DRB Application No.: <u>06DRB-01673 (P&amp;F)</u>	Project # <u>1005267</u>
Project Name: <u>ALLWOODS SUBDIVISION</u>	
Agent: <u>Lloyd Goldrick AIA</u>	Phone No.: <u>883-9100</u>

**CITY OF ALBUQUERQUE  
PLANNING DEPARTMENT  
December 13, 2006  
DRB Comments**

**RE: Tract 3-A Cashway Building Materials/p&f**

PLAT FOR
TRACT 3-A, BLOCK G
CASHWAY BUILDING MATERIALS, INC.
ALLWOODS SUBDIVISION
 WITHIN THE ELENA GALLEGOS GRANT
 PROJECTED SECTION 35, T11N, R3E, N.M.P.M.

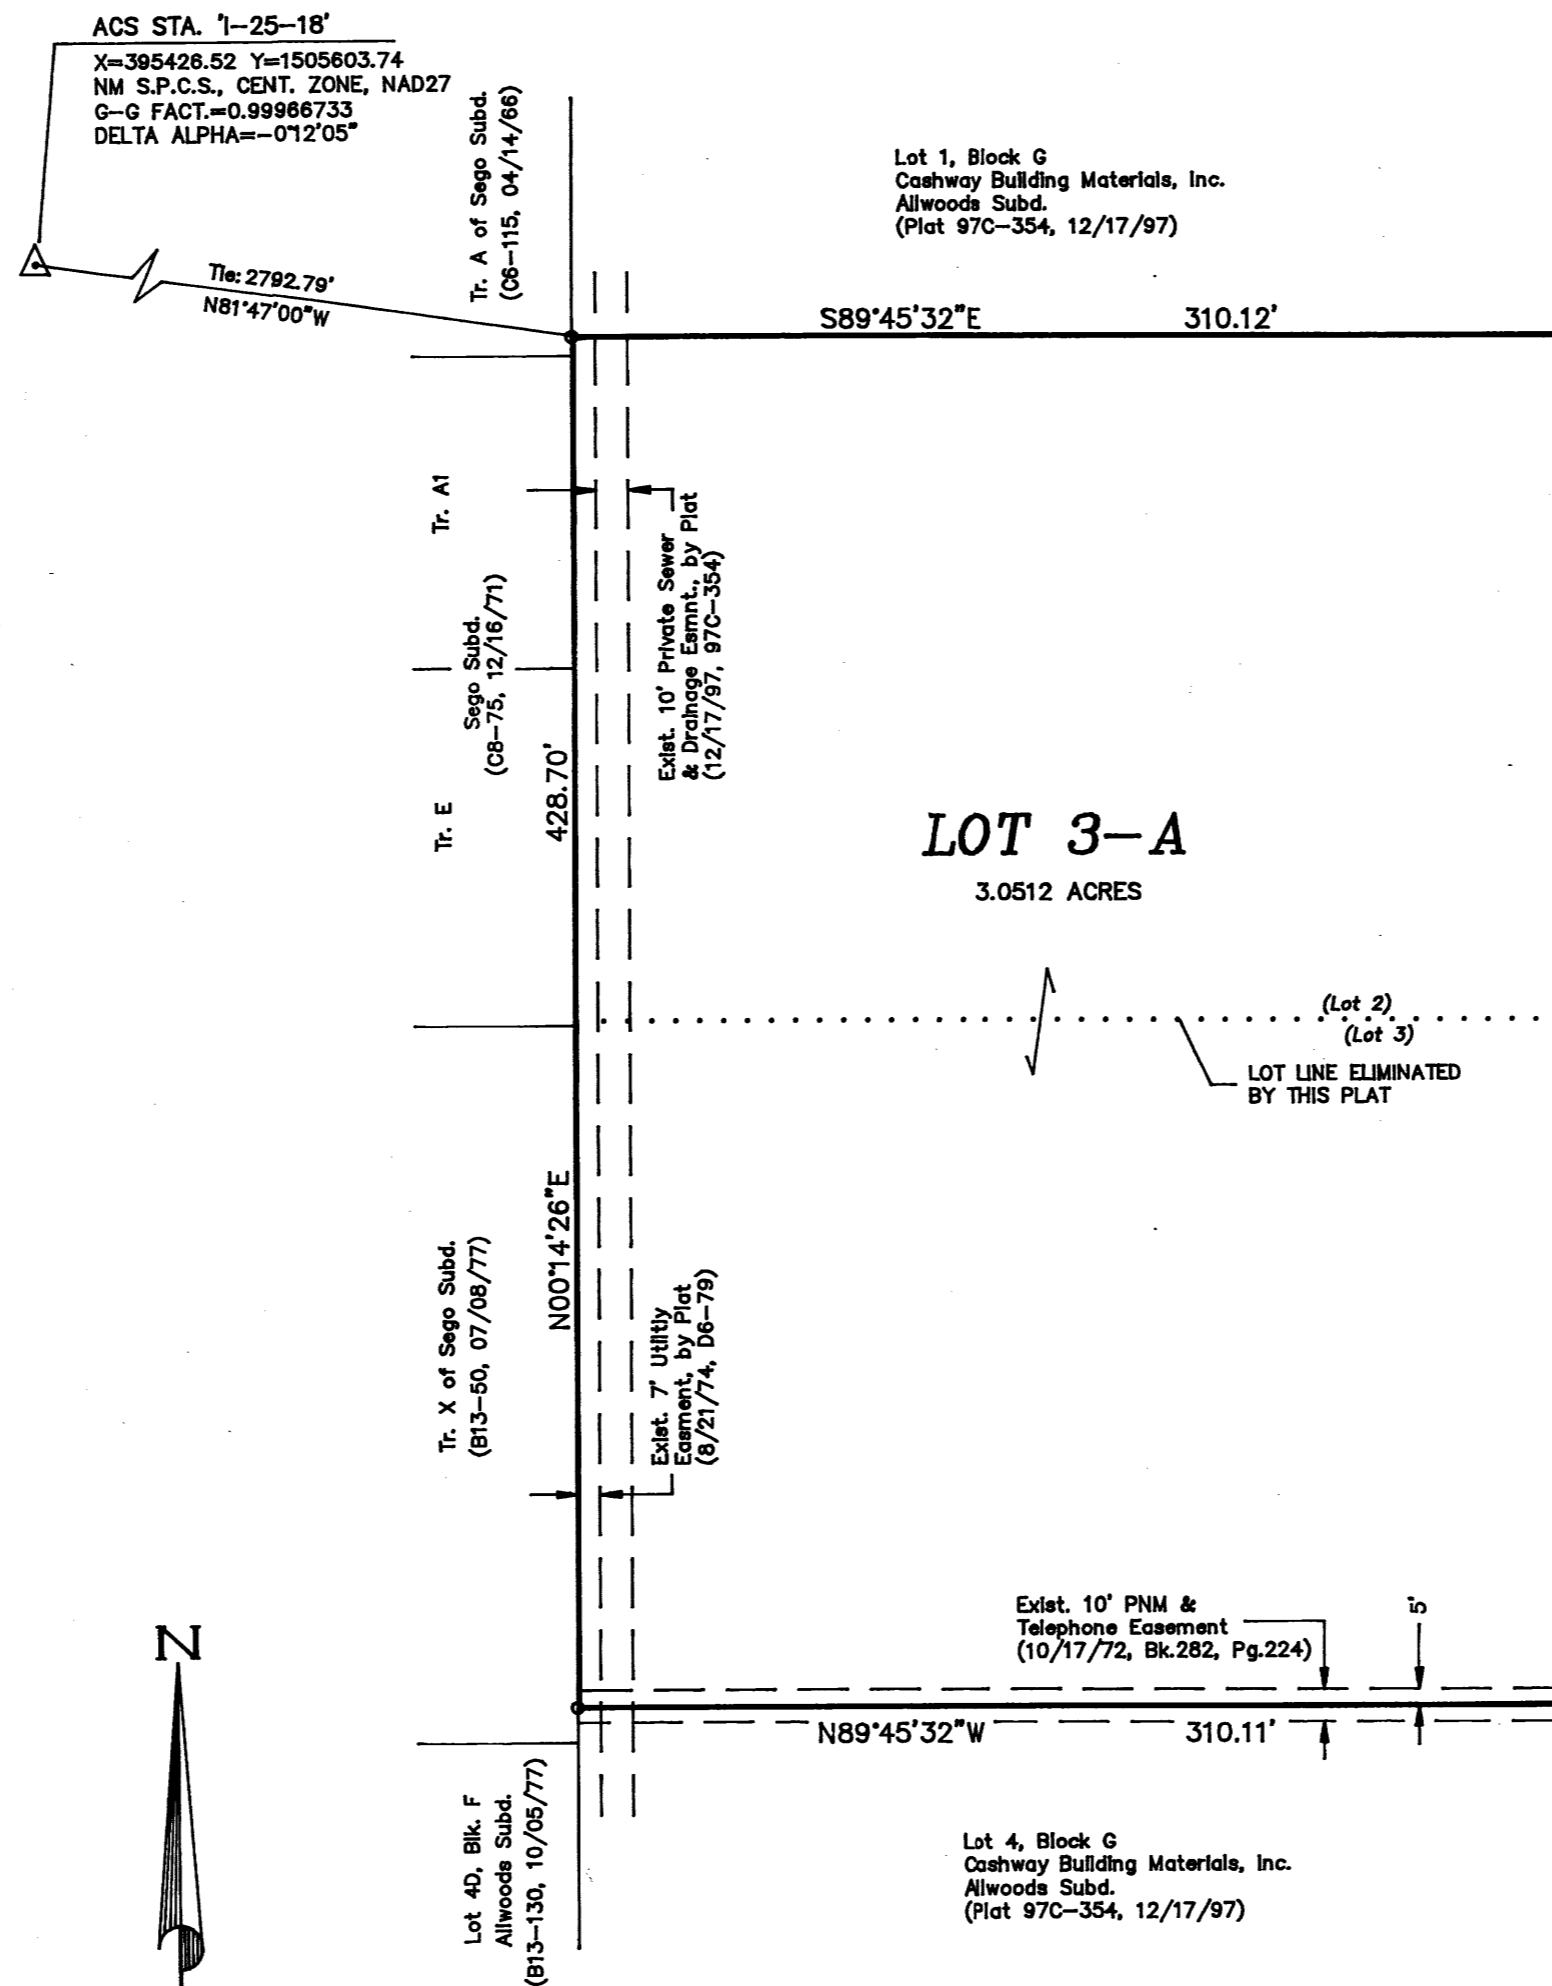
The zoning designation C-3 is missing on the plat.
